PROJECT INFORMATION			
Space Village Filing No. 4	4/17/2023	MS227	
Project Name	Date	PCD File No.

Unresolved Review 2
 Comment:
 - Include costs for as-built plans and pond certification letter.

DRAINAGE CHANNEL PLAN

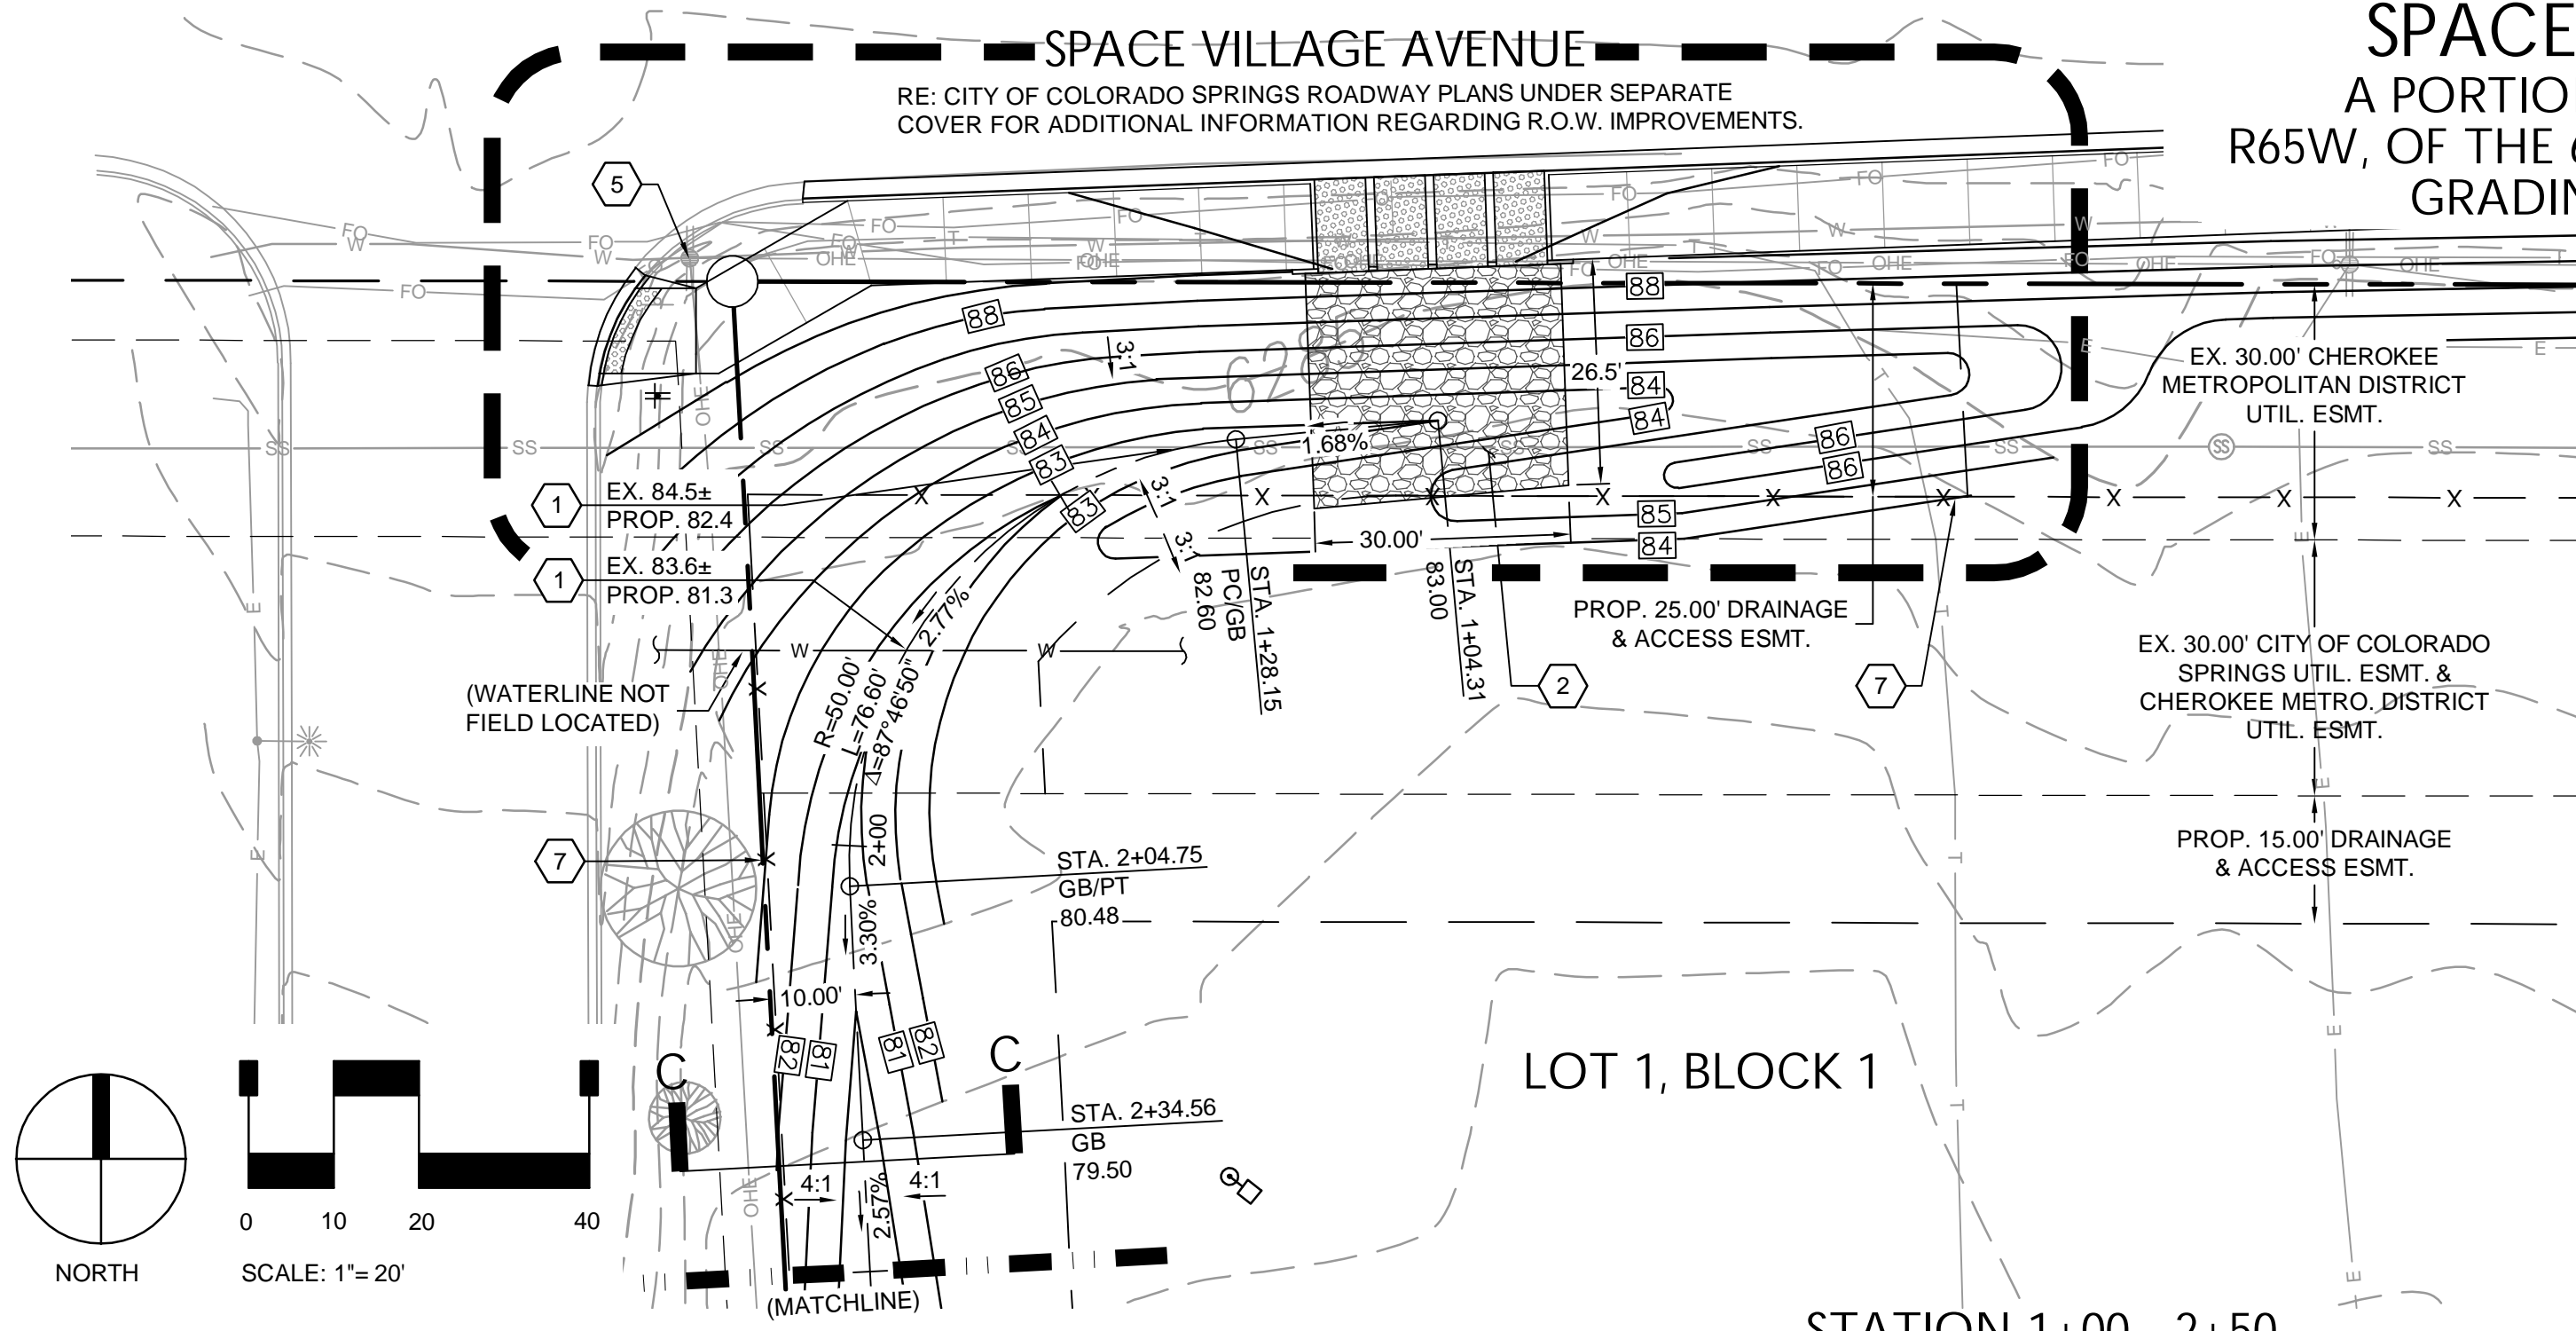
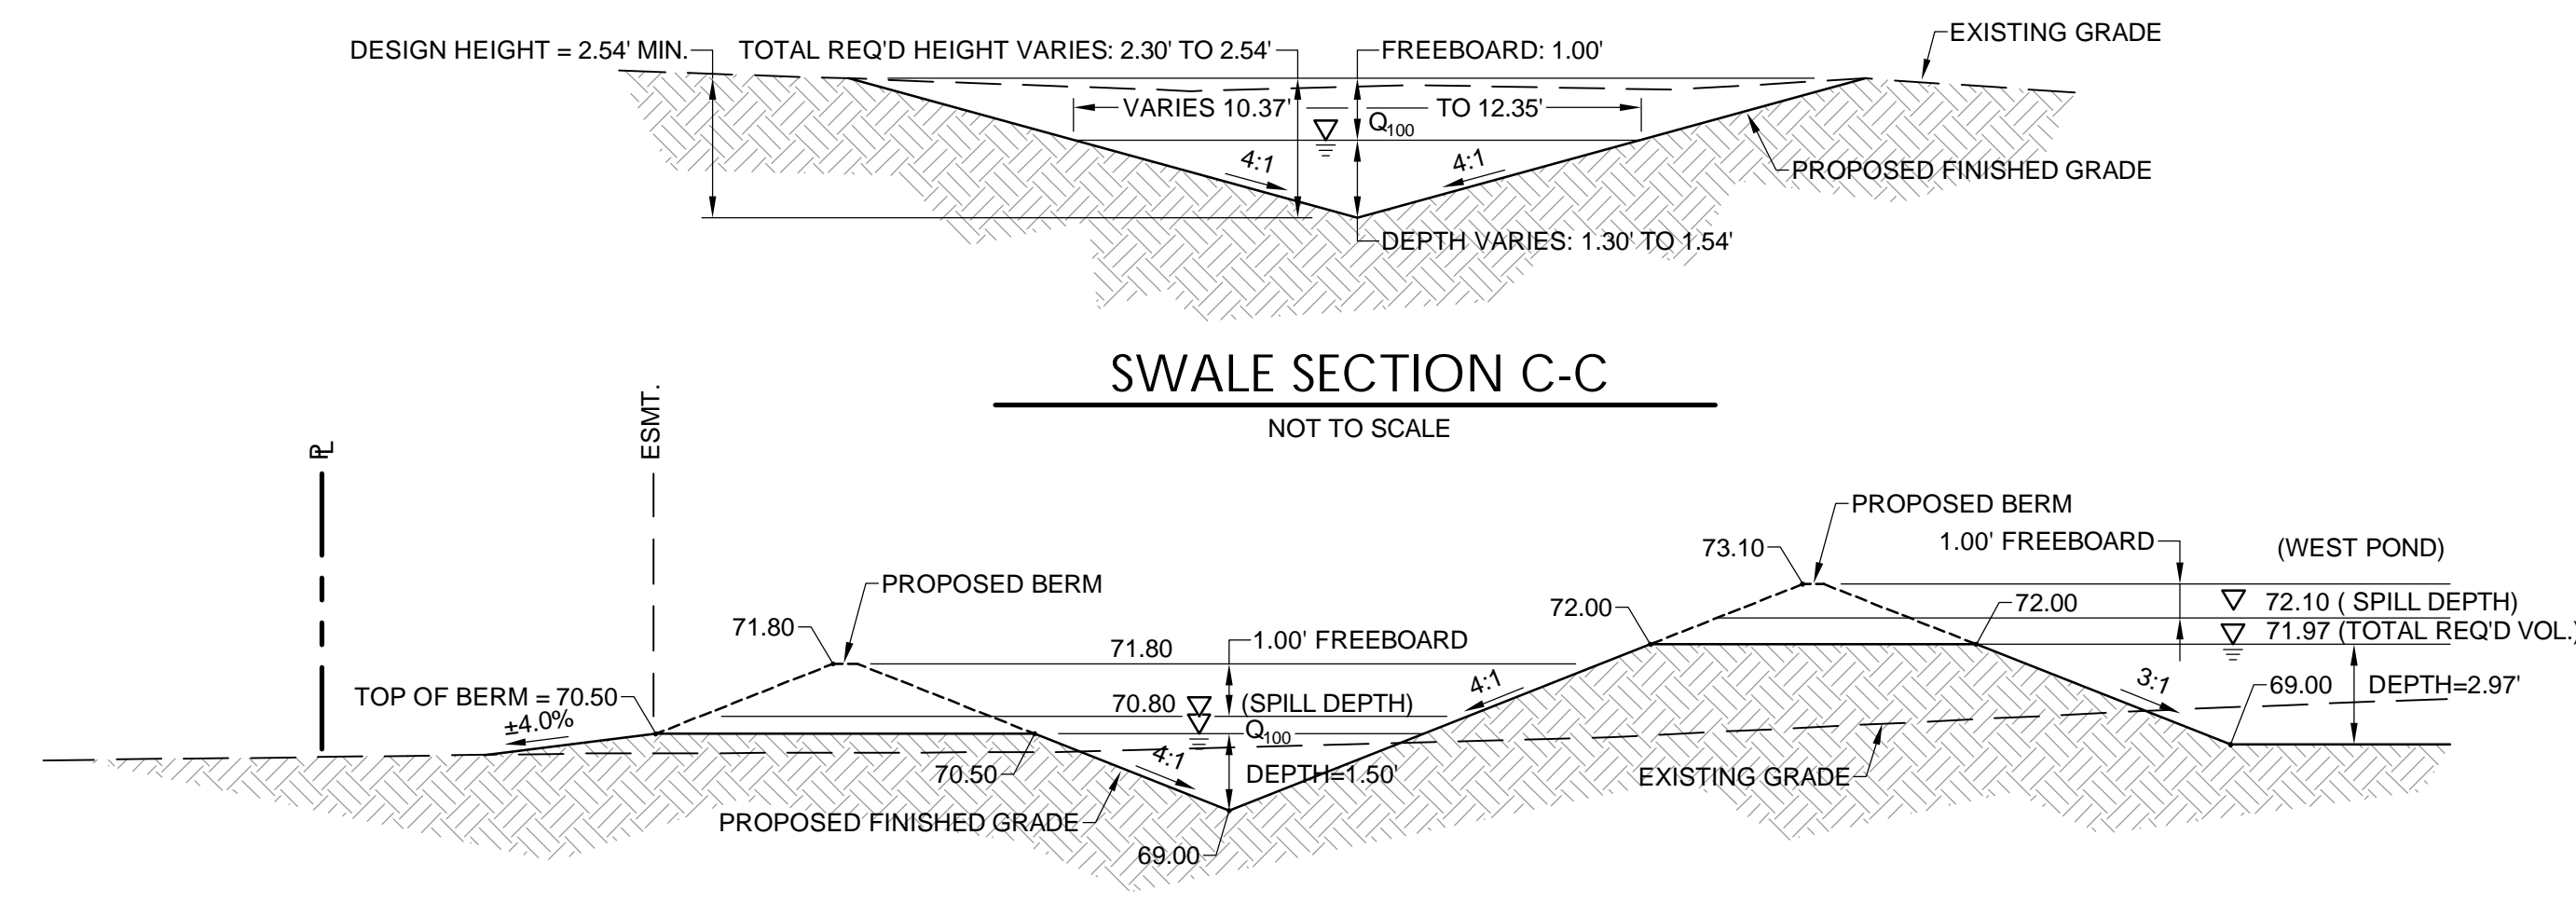
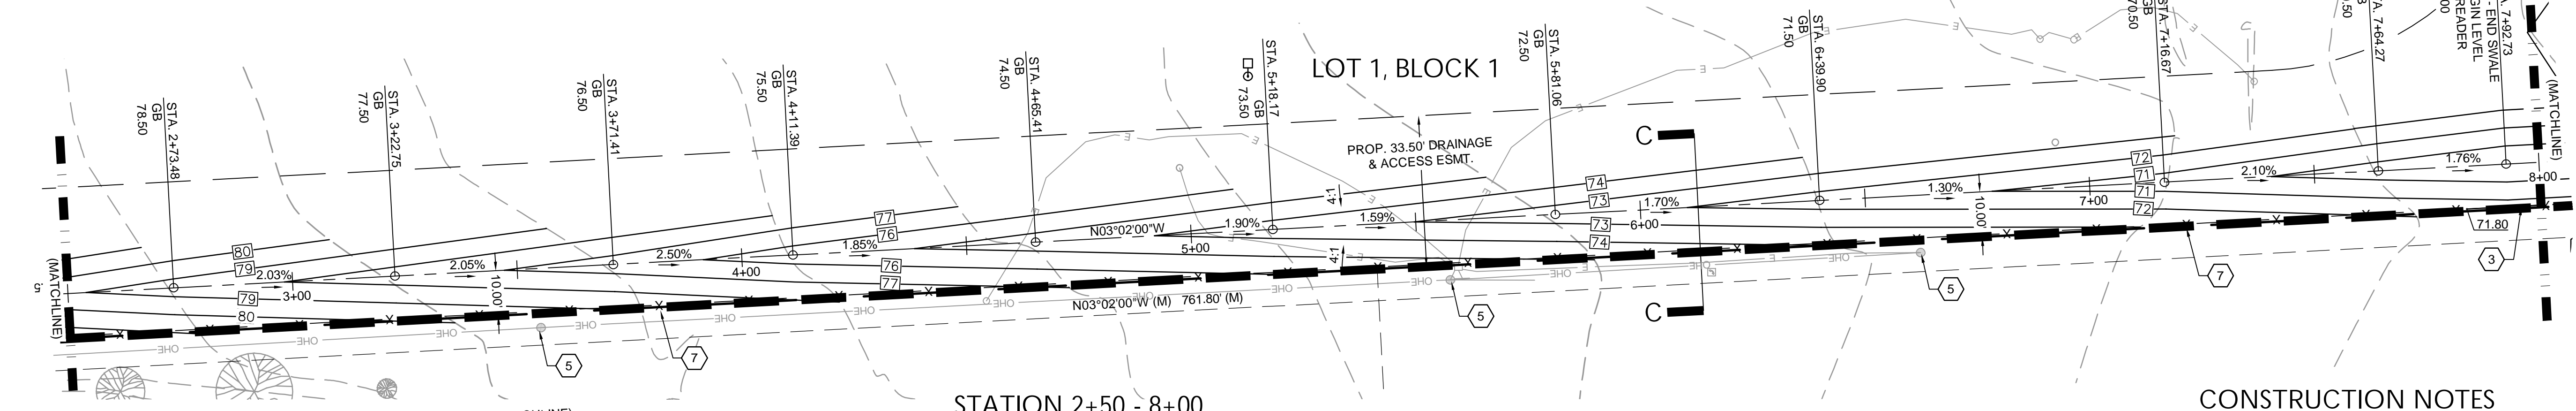
Fill out for the proposed channels and move them to section 3.

and level spreader

See responses above. Cost reflects grading. Seeding added per response. Riprap rundowns included. In Section 3 per comment.
